Application Reference Number:	2026/0107		
Application Type:	Householder		
Proposal Description:	Erection of detached double garage		
Location:	30A Fearn House Crescent, Hoyland, Barnsley, S74 0BA		
Applicant:	Mr Neil Whitlam		
Third-party representations:	None	Parish:	None
		Ward:	Rockingham

This planning application seeks householder planning permission for the erection of detached double garage. A previous application for a double garage 2023/0906 was refused at the same site.

Summer Solstice 12PM

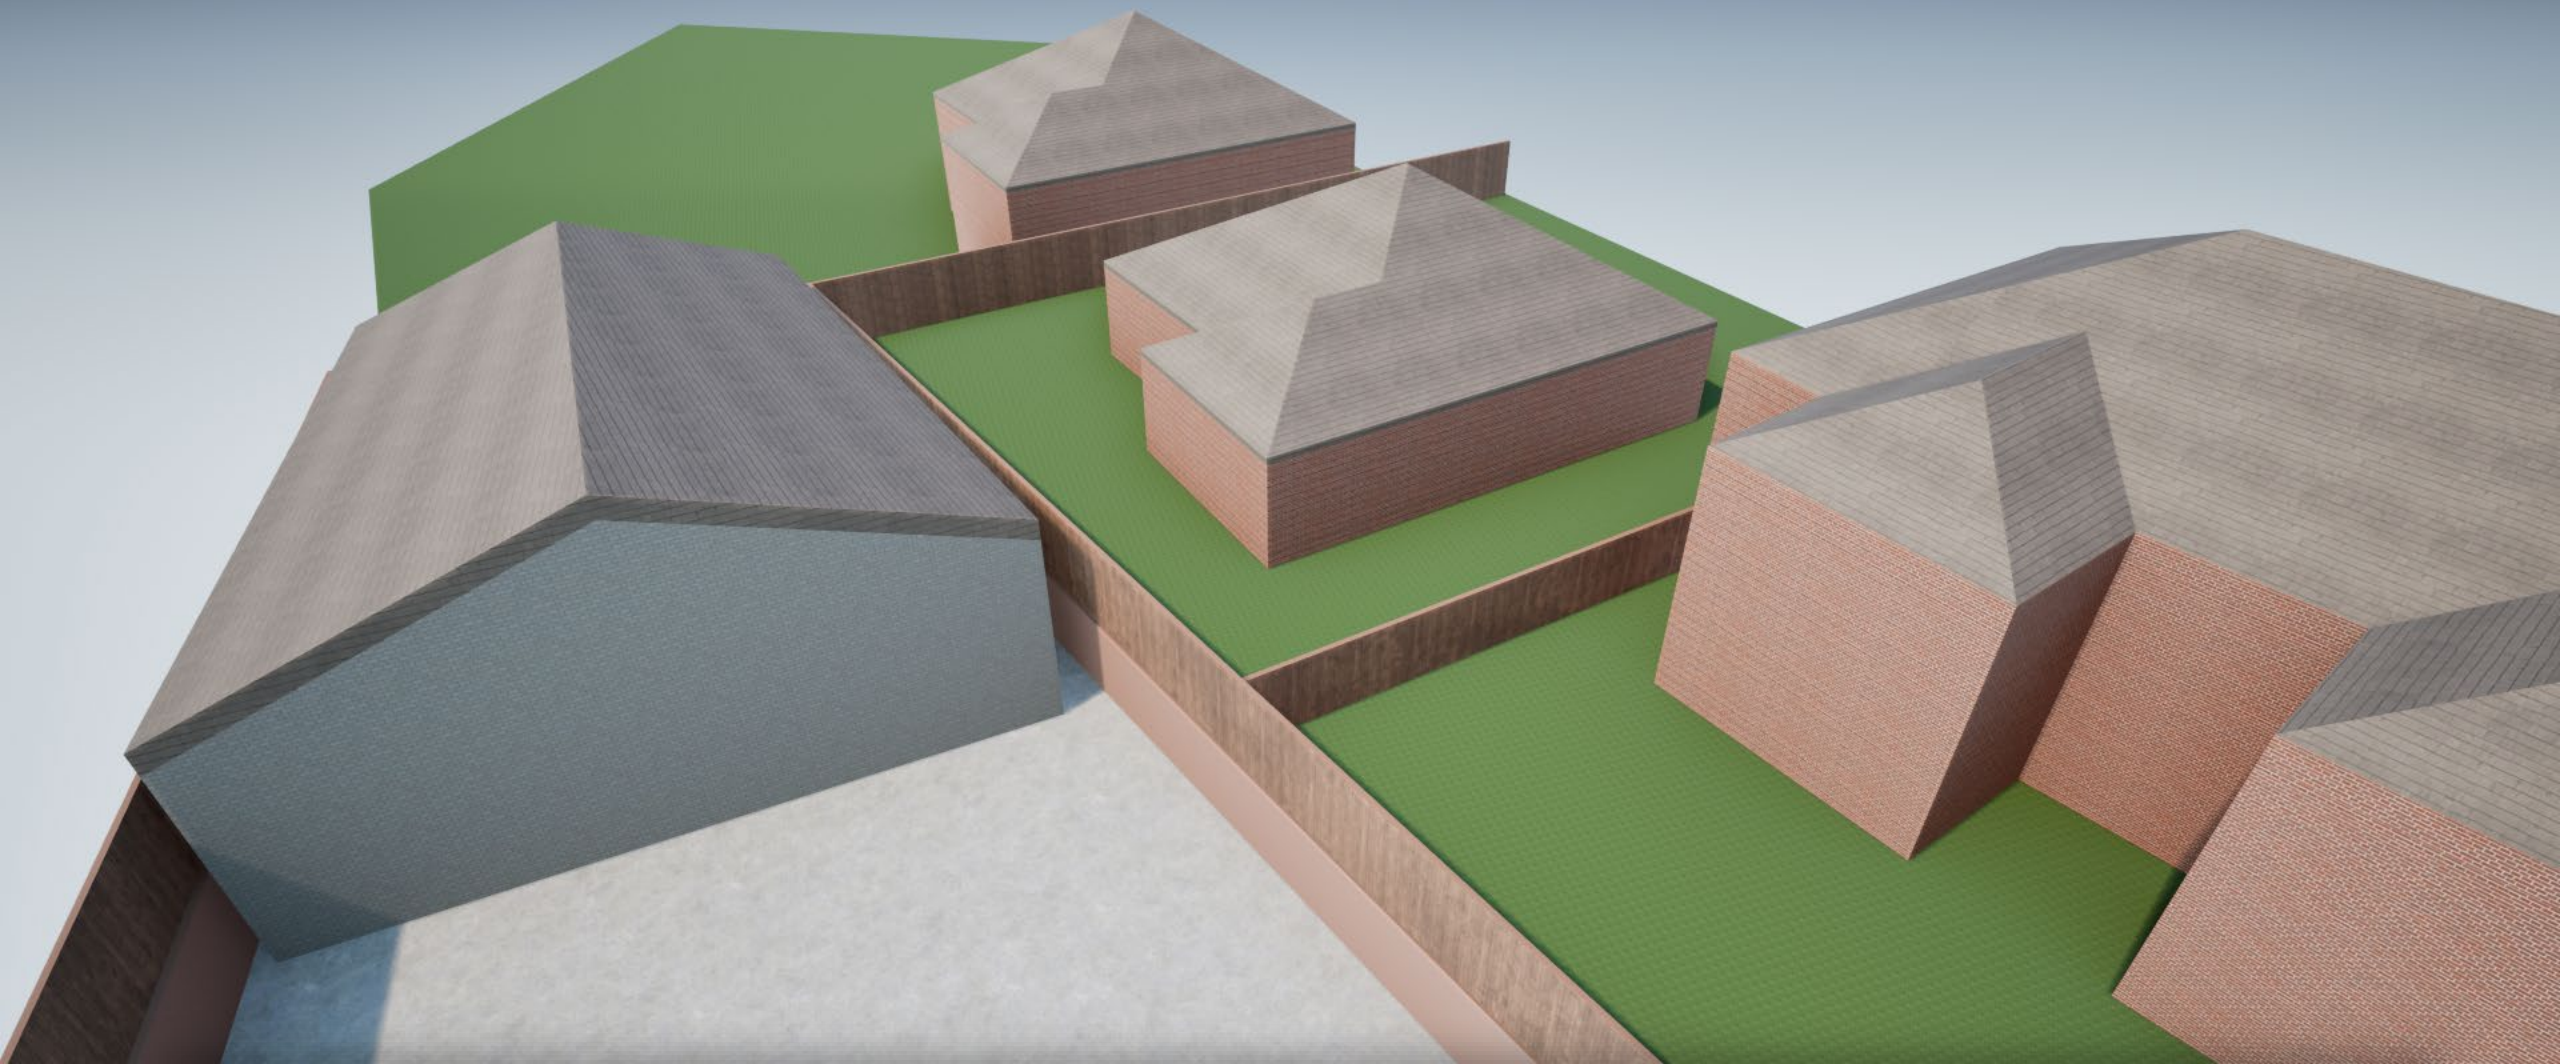
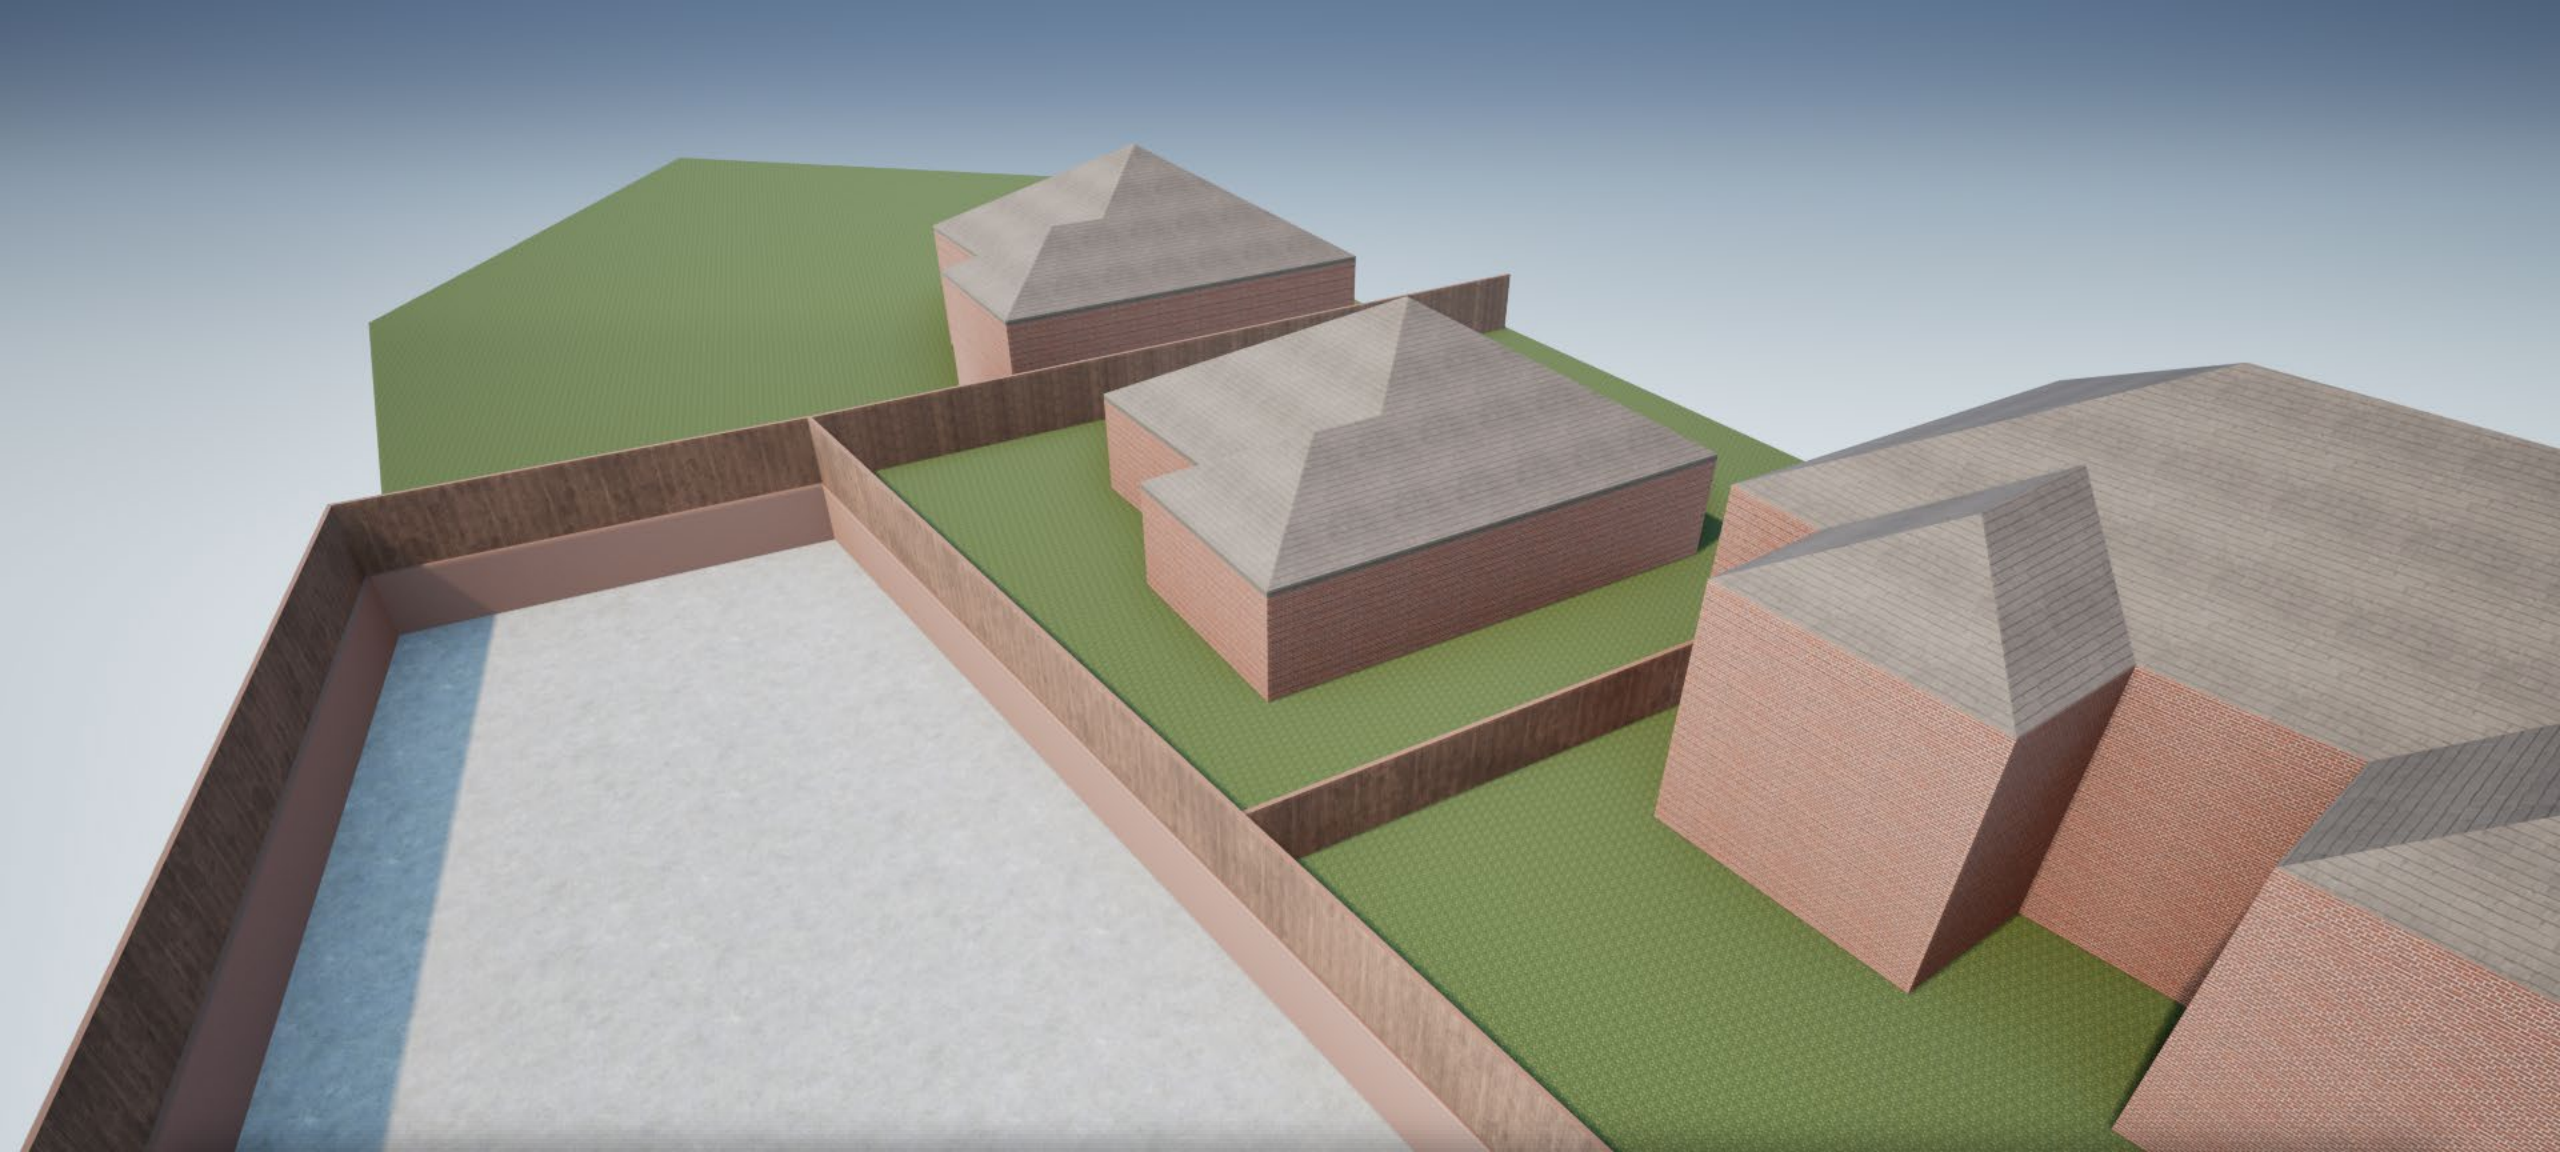
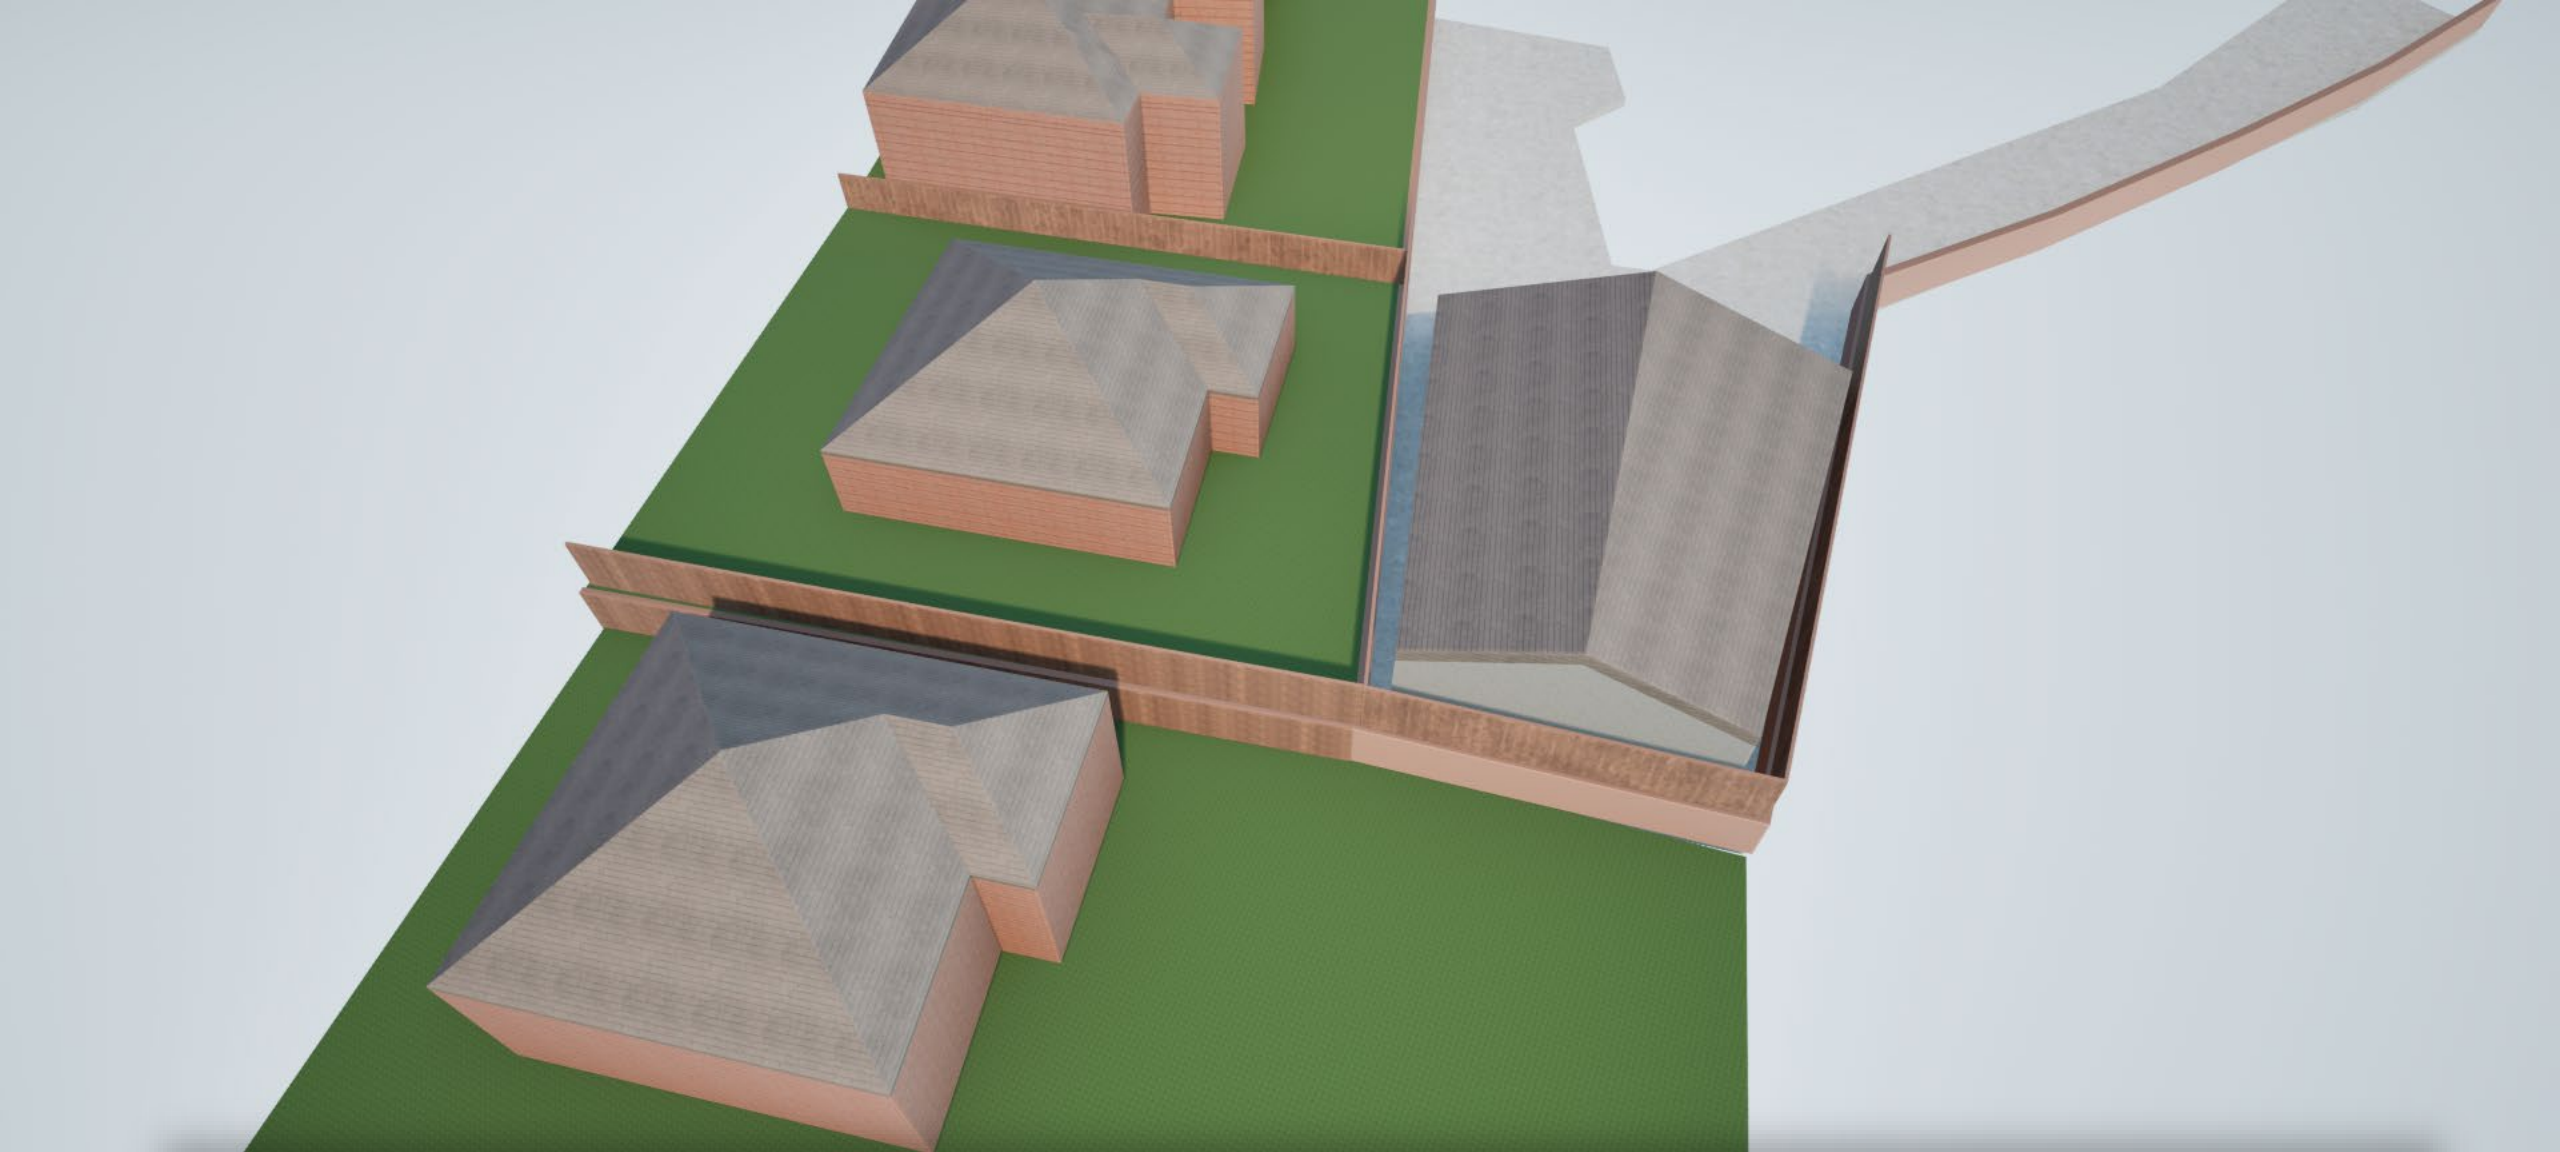
It is noted that the applicant has provided a shadow impact report and analysis which shows the potential impact of shadows created by the proposed garage. The report deems the impact to be negligible and that there will be no adverse impact upon neighbouring properties. The LPA disagrees with this assessment. The analysis also shows the size of the proposed garage in relation to the neighbouring properties further underling the point regarding the excessive size and scale.

It is therefore still deemed that the proposed garage would cause a significant overshadowing of 282A West Street, its rear habitable room windows and its rear garden area. As such the proposal is not in compliance with Local Plan Policy D1 in that it is of poor design and would also be in conflict
